I have great concerns regarding the proposed development by the University of Sydney, MP 07_0158 – Abercrombie Street Precinct, Syd Uni. Our school is directly next to the western border of the project.

Scale and position of the new Business Building

Drawing title
PROPOSED SITE OVERVIEW

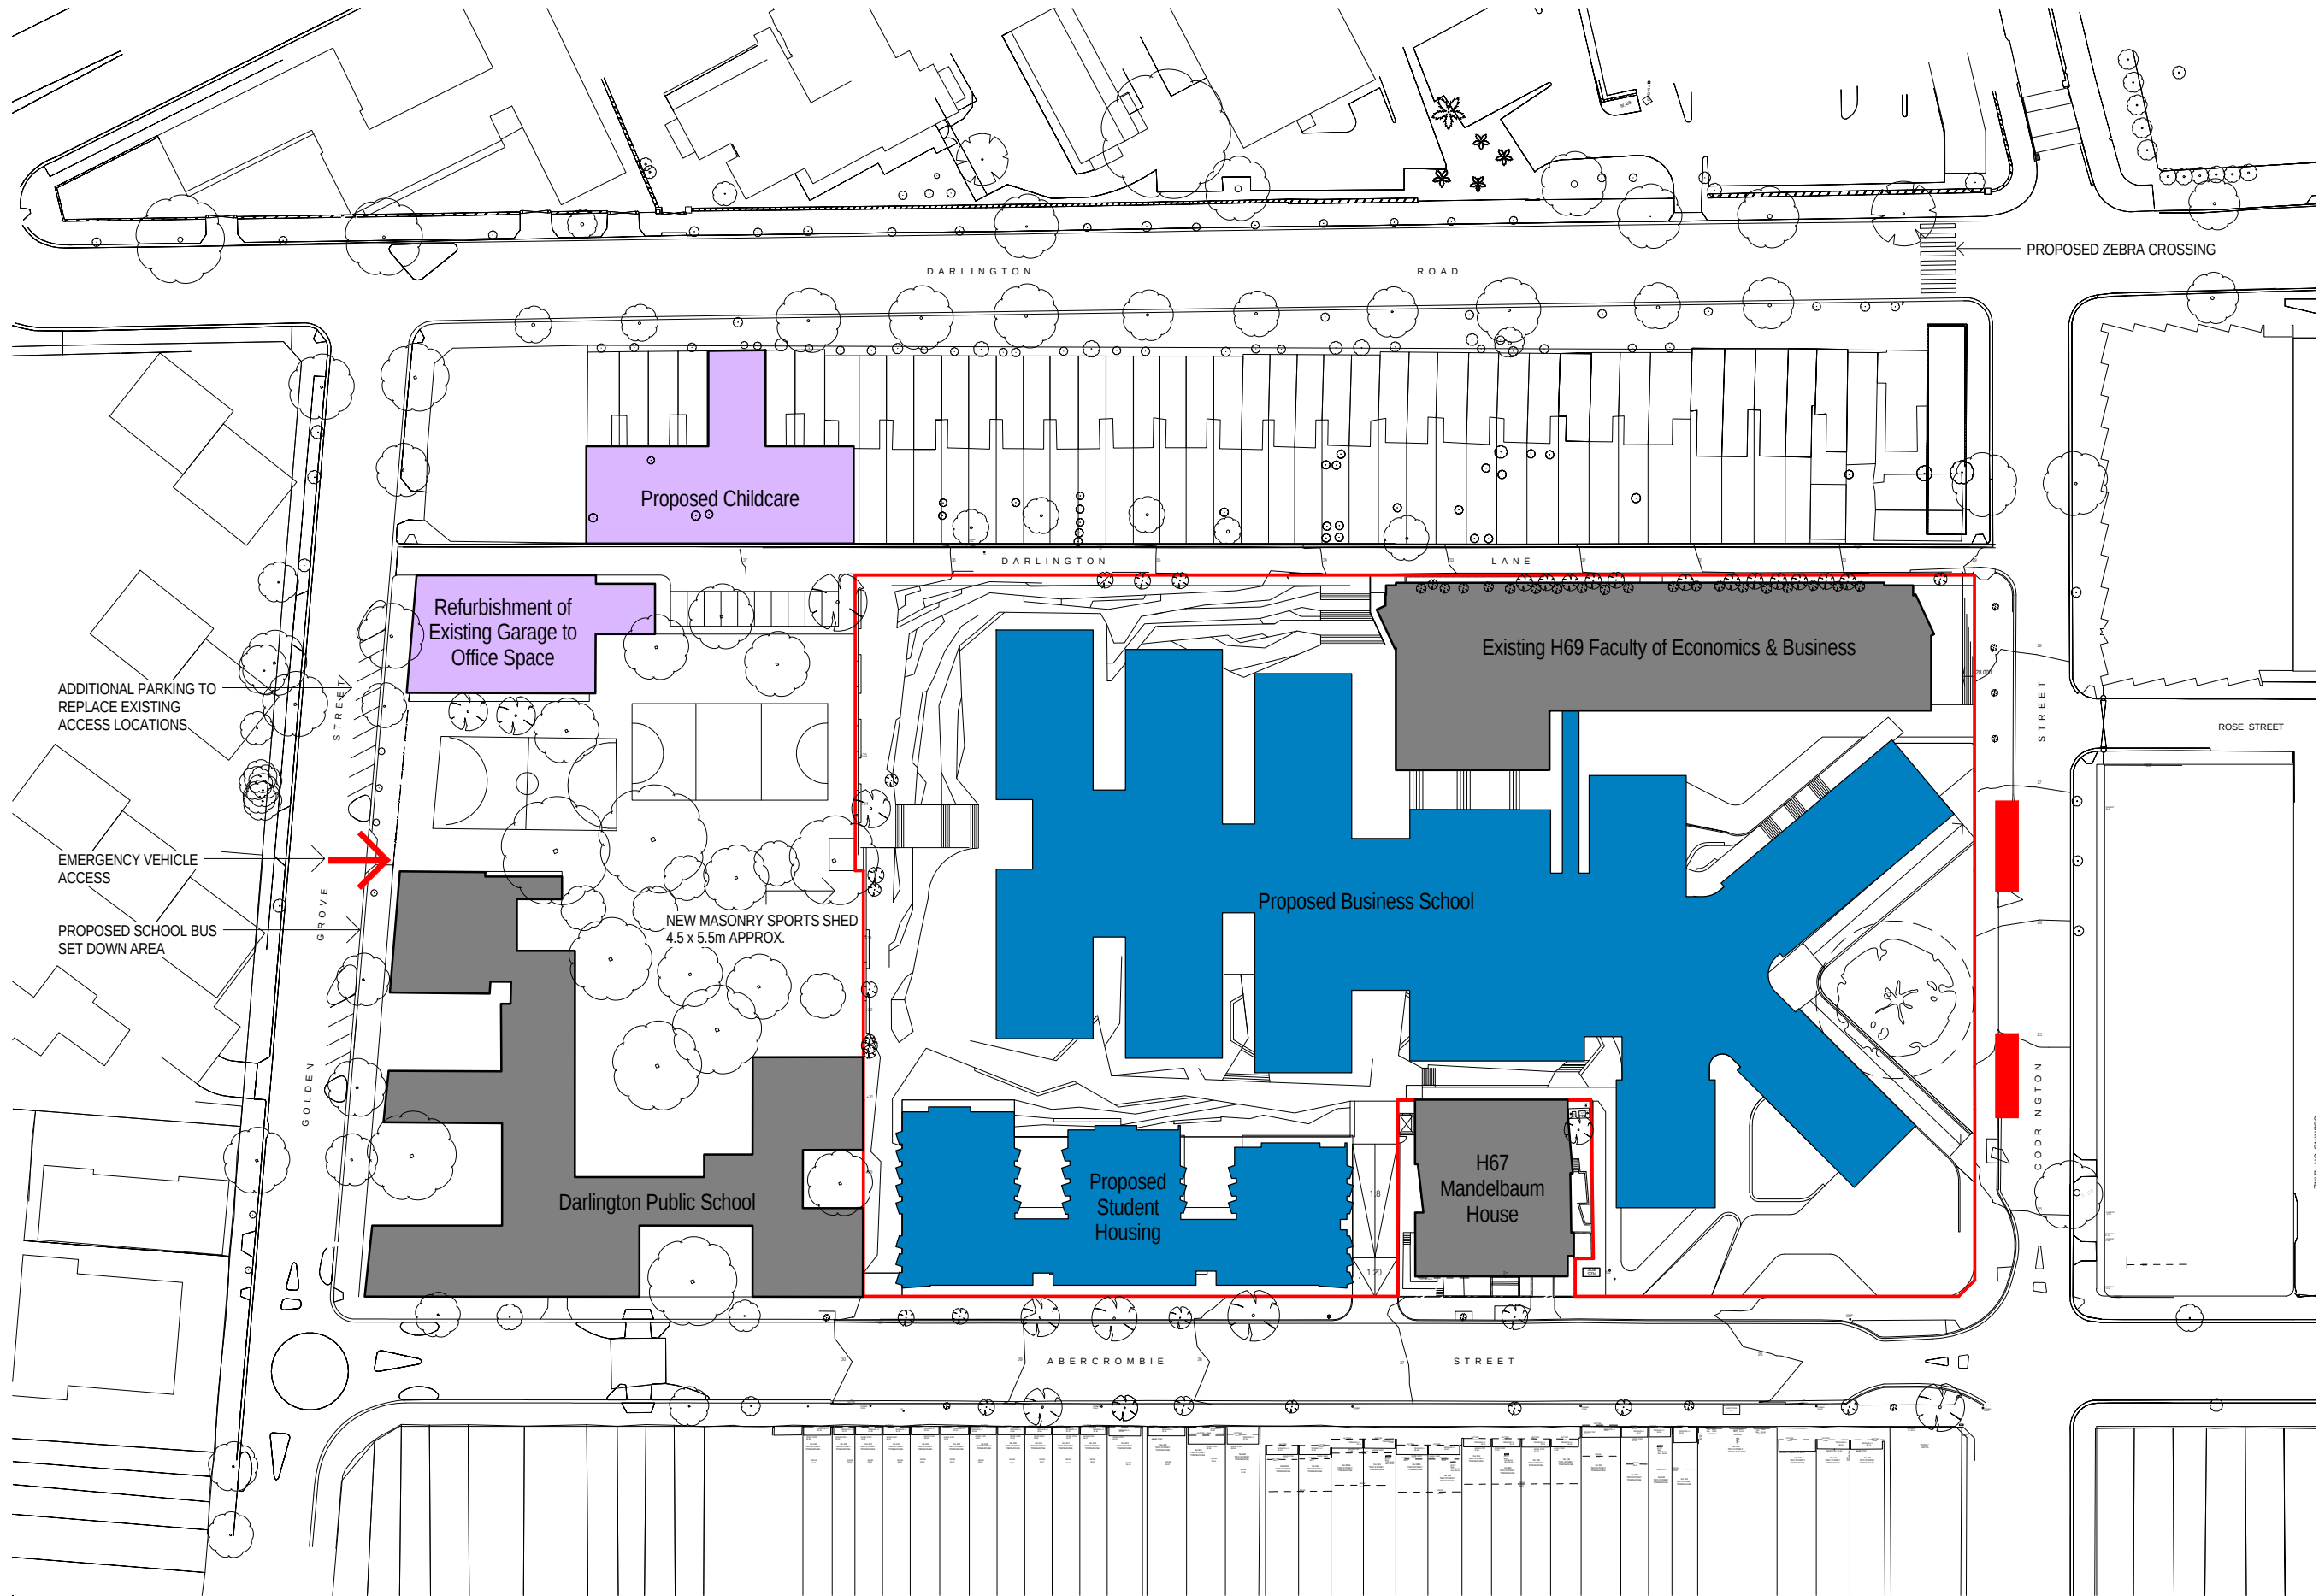
The proposal calls for an underground car park to be built for the student accommodation and University staff. The car park will accommodate 185 car spots, and its entrance will be on Abercrombie Street, at approximately the same point of the construction access.

The concerns raised above about the access point to the construction site (see below) are the same for this car park access point increasing the risk to school children's safety, in an area that has already been highlighted through the respective organisations (Council, Police, and RTA). The increased traffic flows and access point are an unacceptable risk to the children who attend the school. There is no justification for this level of risk to a school community, particularly as the University has another street frontage without school or residential issues (the University being the only stakeholder for Codrington Street) and an access street internal to project (Darlington Lane).

Drawing title
SHADOW DIAGRAMS - WINTER
SOLSTICE - JUNE 21

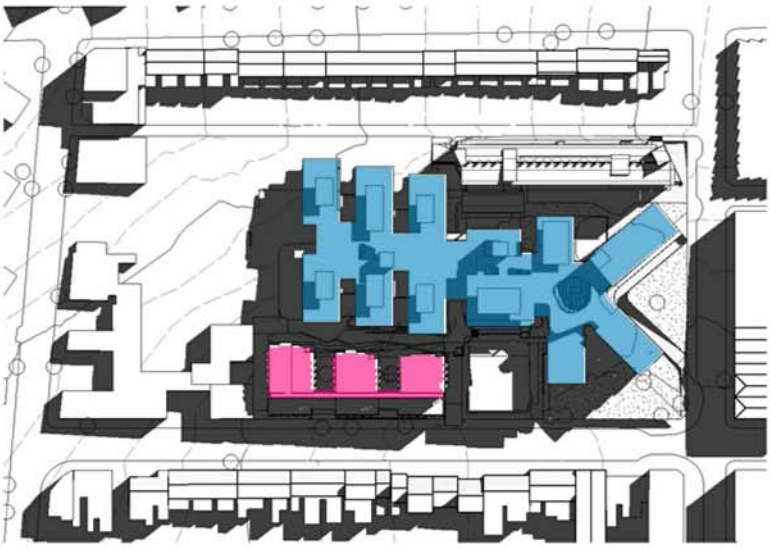
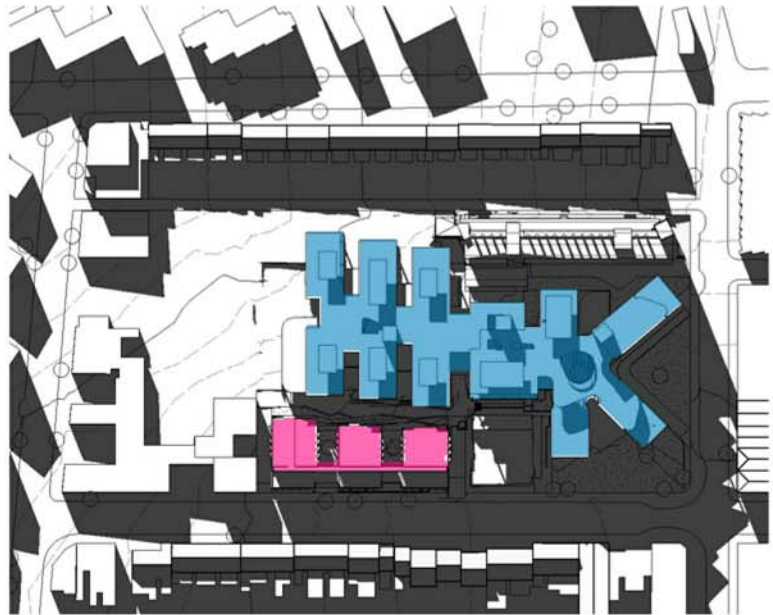
The new Business facility building will be seven stories high, and with its location in the North West corner of the school playground it will cause a large shadow effect over the majority of the playground. This will have a huge effect on the children and also on the small patch of newly laid grass in one area. This is a small but full inner city school which is mostly asphalt and our children need as much light as possible, especially in winter.

What consideration has been given to this impact, and the requirement for natural light for the play areas, making it a suitable area to play?
